From: Laura Gibbons <Laura.Gibbons@arun.gov.uk>
Sent: 11 June 2021 11:49
To: Planning.Responses <Planning.Responses@arun.gov.uk>
Cc: Simon Davis <Simon.Davis@arun.gov.uk>
Subject: RE: Planning Consultation on: BN/54/21/DOC

Condition 10- surface water drainage design

Application No: BN/54/21/DOC

Site Address: Land Rear Of 1 Northfields Cottages Fontwell Avenue Eastergate PO20 3RX

Figure 2: Typical total infiltration permeable pavement system detail

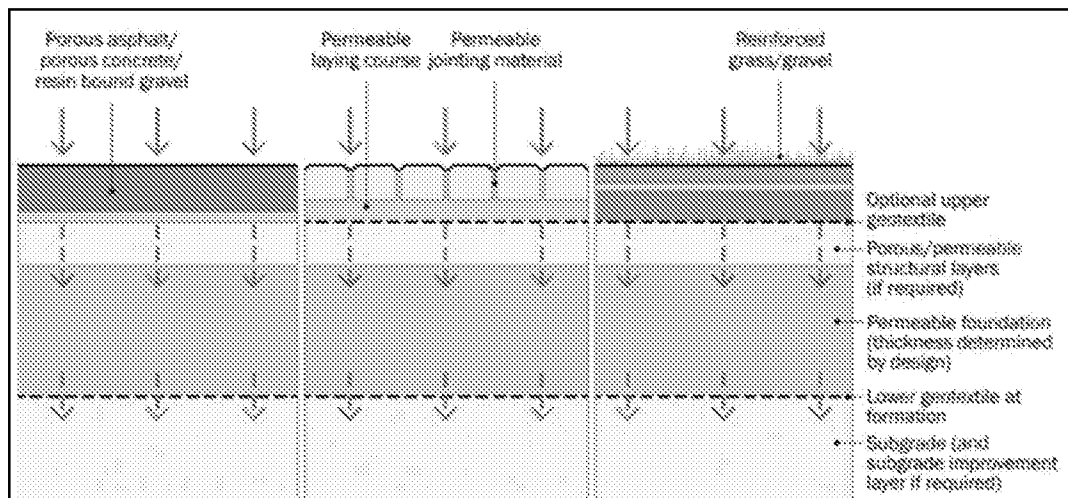
- The maintenance manual must include details of how maintenance of communal features will be funded.
- Please include details of the maintenance requirements of vortex separators.
- Until the surface water drainage design has been finalised we cannot recommend discharge of this condition.
